KIRKLEES METROPOLITAN COUNCIL INVESTMENT & REGENERATION SERVICE

DELEGATED DECISION FOR DISCHARGE OF CONDITION A1 - NOTIFICATION OF A PROPOSED DEVELOPMENT UNDER LOCAL OR PRIVATE ACTS OR ORDER

Reference no. 2026/CL/90198/W

Description	Prior approval for alterations to bridge MVL3/54, Kettle Lane, north- east of Marsden
--------------------	---

Drawing Title: **Prior Approval - MVL3/54 Kettle Lane - Existing and Proposed Elevation and Section**

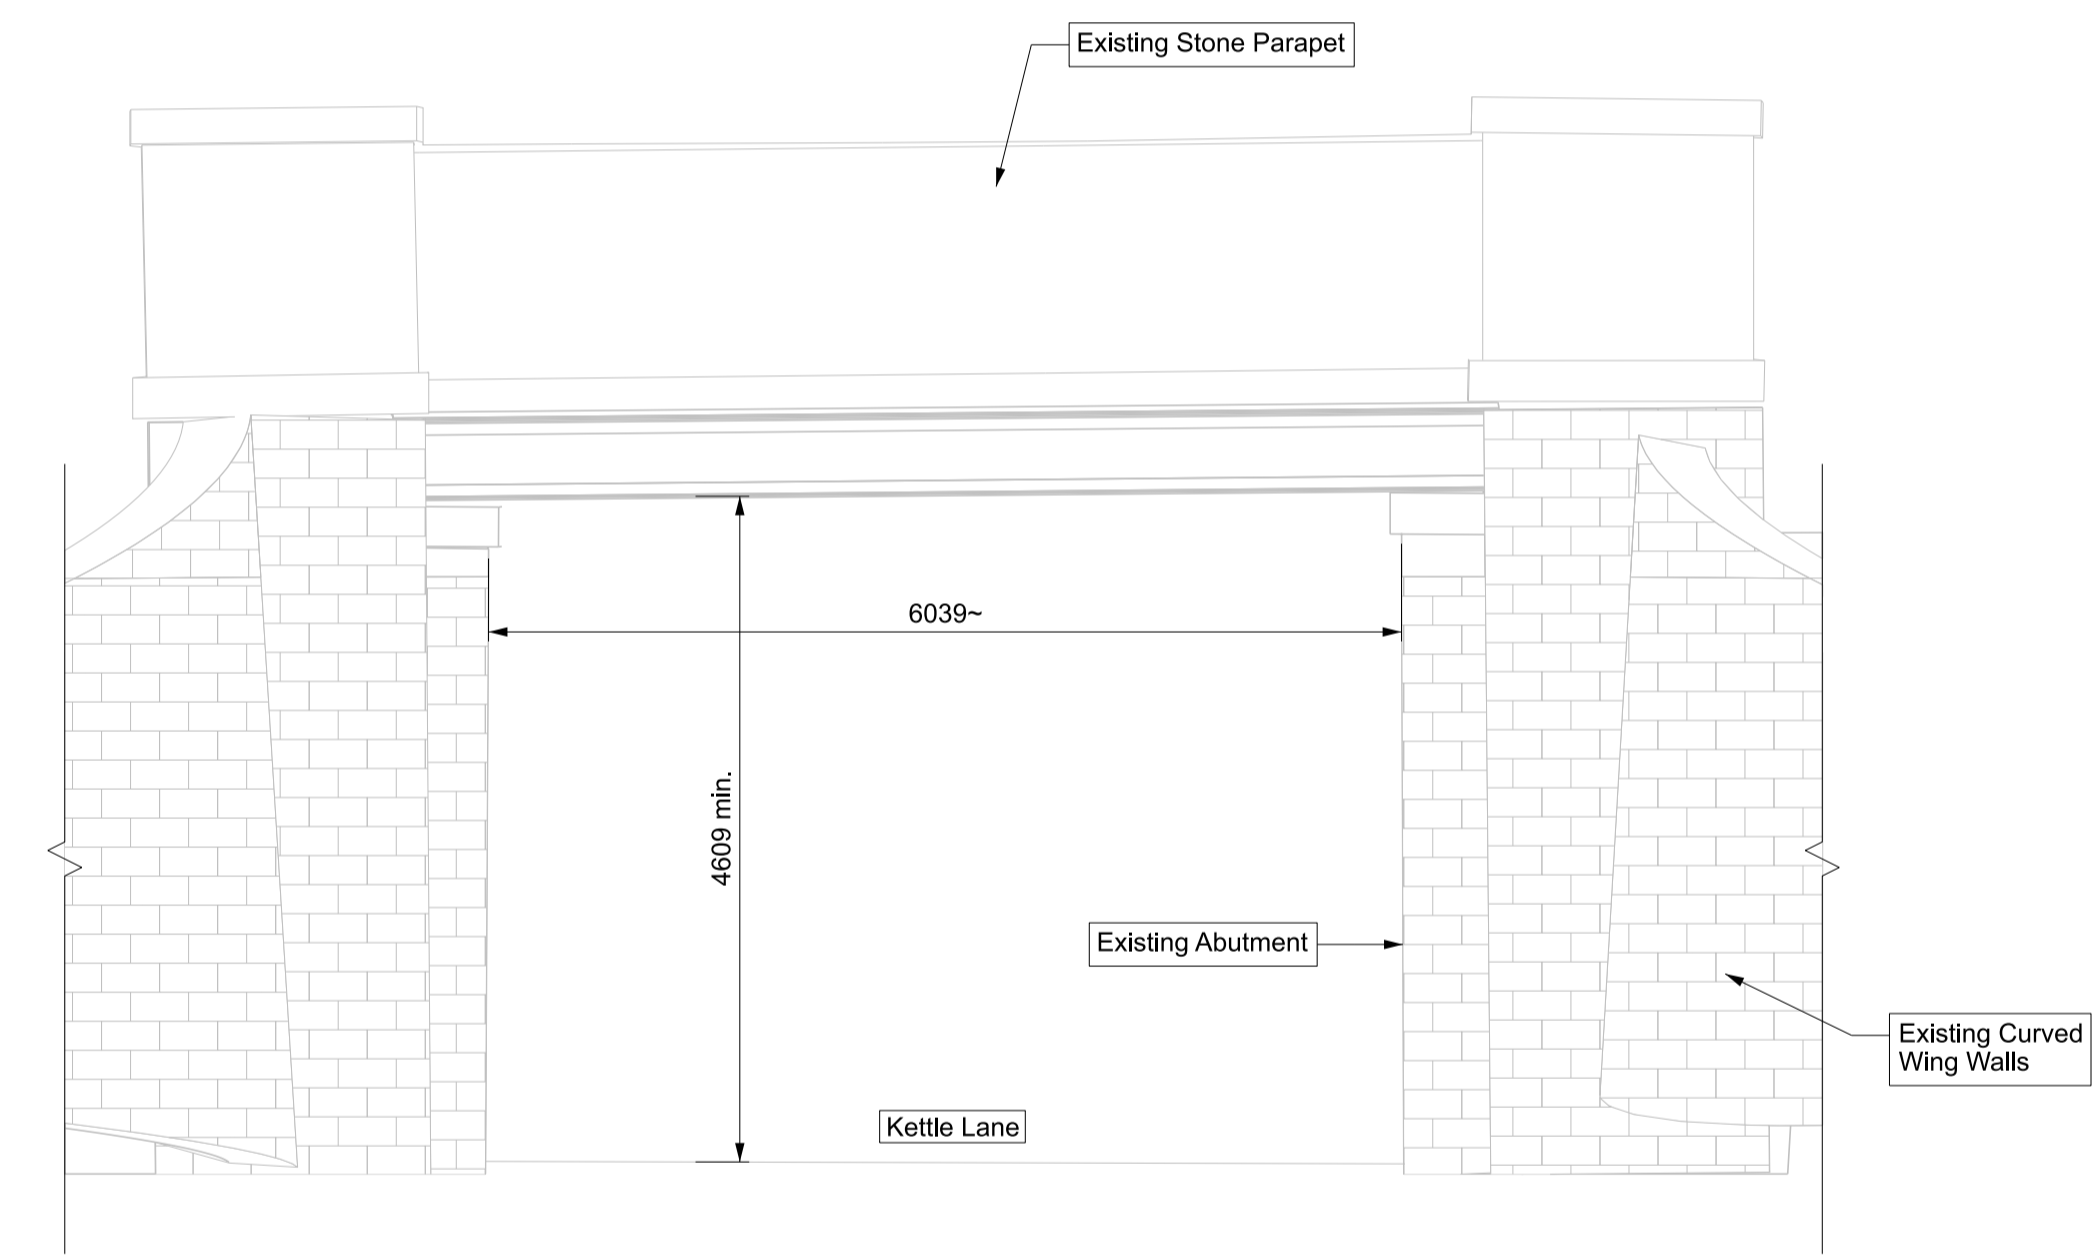
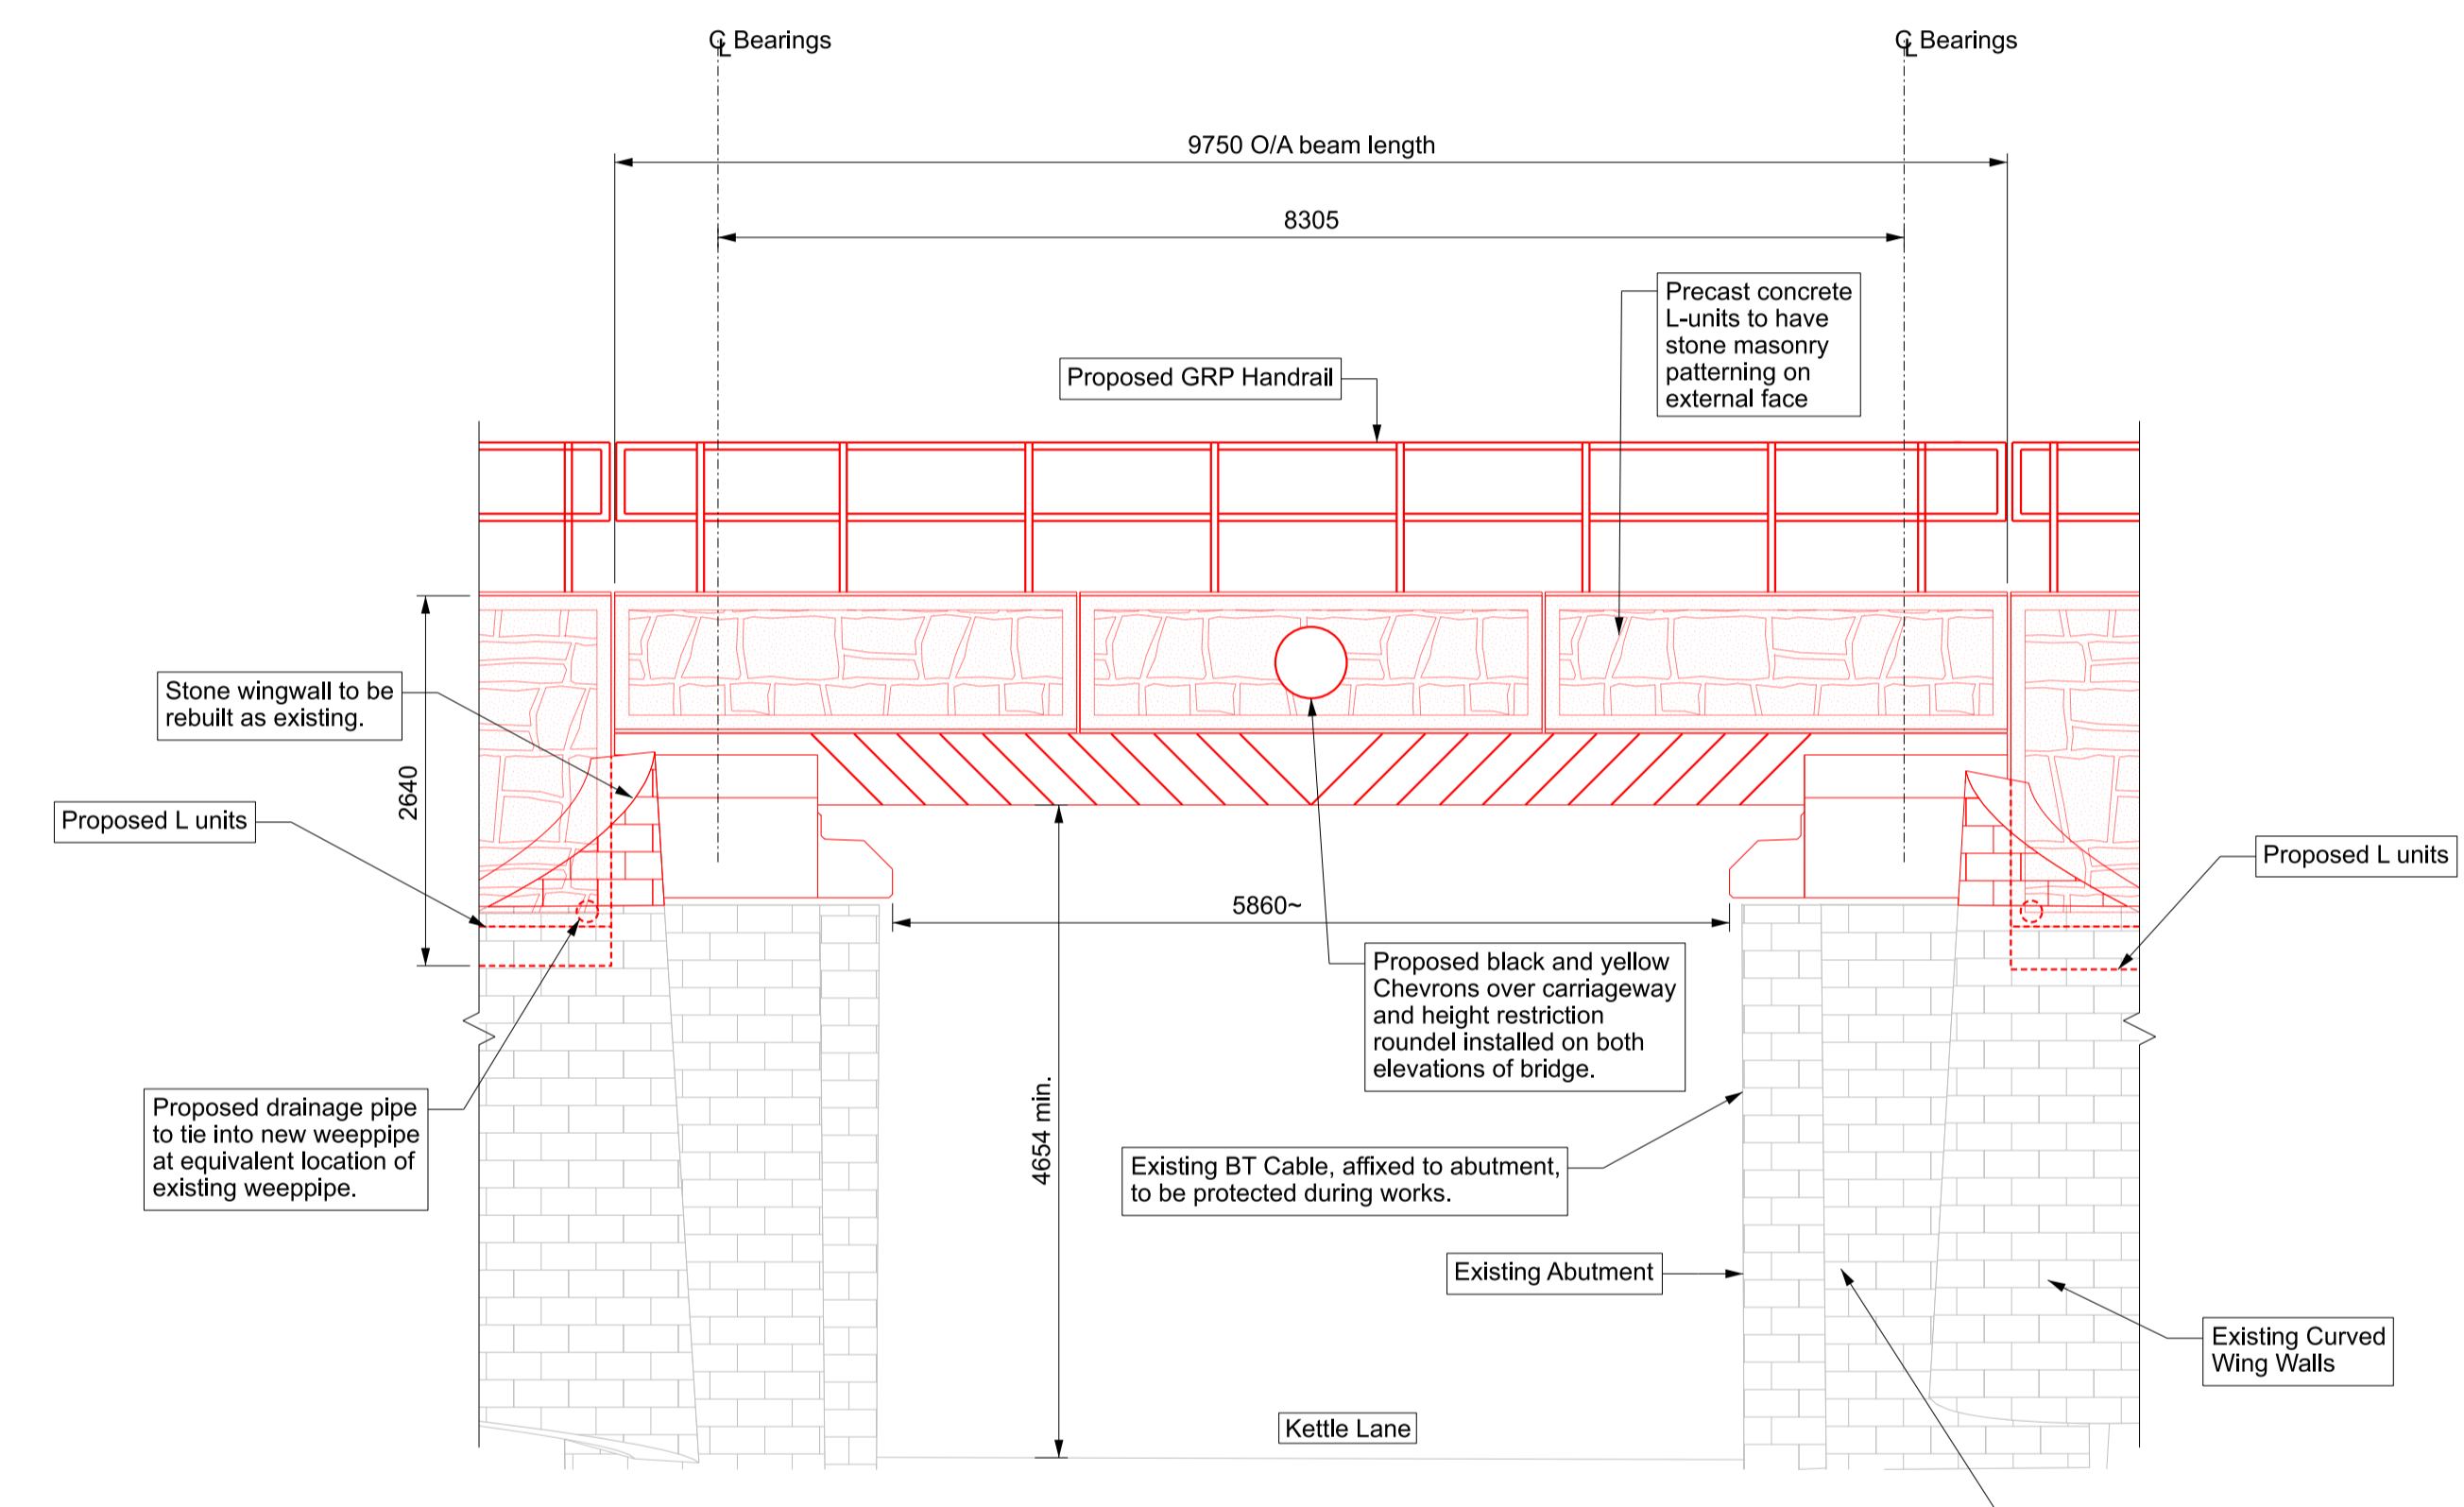
- *The pre-cast concrete L-units shall be finished with natural stone cladding design pattern to match the natural coursed stones below. The concrete shall match the existing natural stones by colour, texture and coursing.*
- *The GRP handrail shall be finished in a black or green colour*

The proposed works retain, where possible, the original features of the bridge by maintaining the stone wingwalls and where removal of the existing bridge structure is required, the use of pre-cast concrete with stone masonry patterning is proposed. Conservation and Design officers have advised that this may not be appropriate. The applicant has advised that they are unable to provide alternative materials and design details at this stage in the process and therefore suggested a condition for the submission of parapet materials, design and finish which is considered acceptable. As such, there is no objection to the proposed works, subject to the application of suitably worded conditions for the submission of parapet materials and the finish of the proposed handrails.

- The submission of material finish/detail to be agreed by the LPA
- The GRP handrail shall be finished in a black or green colour.

1. Notwithstanding the submitted plans, a sample of the parapet finish[es] shall be submitted to and approved by the Local Planning Authority, prior to their installation. The external treatment of the parapet finish[es] shall reflect the retained stonework of the bridge in terms of colour, texture, finish and coursing.

2. The GRP handrail shall be finished in a black or green powder coating
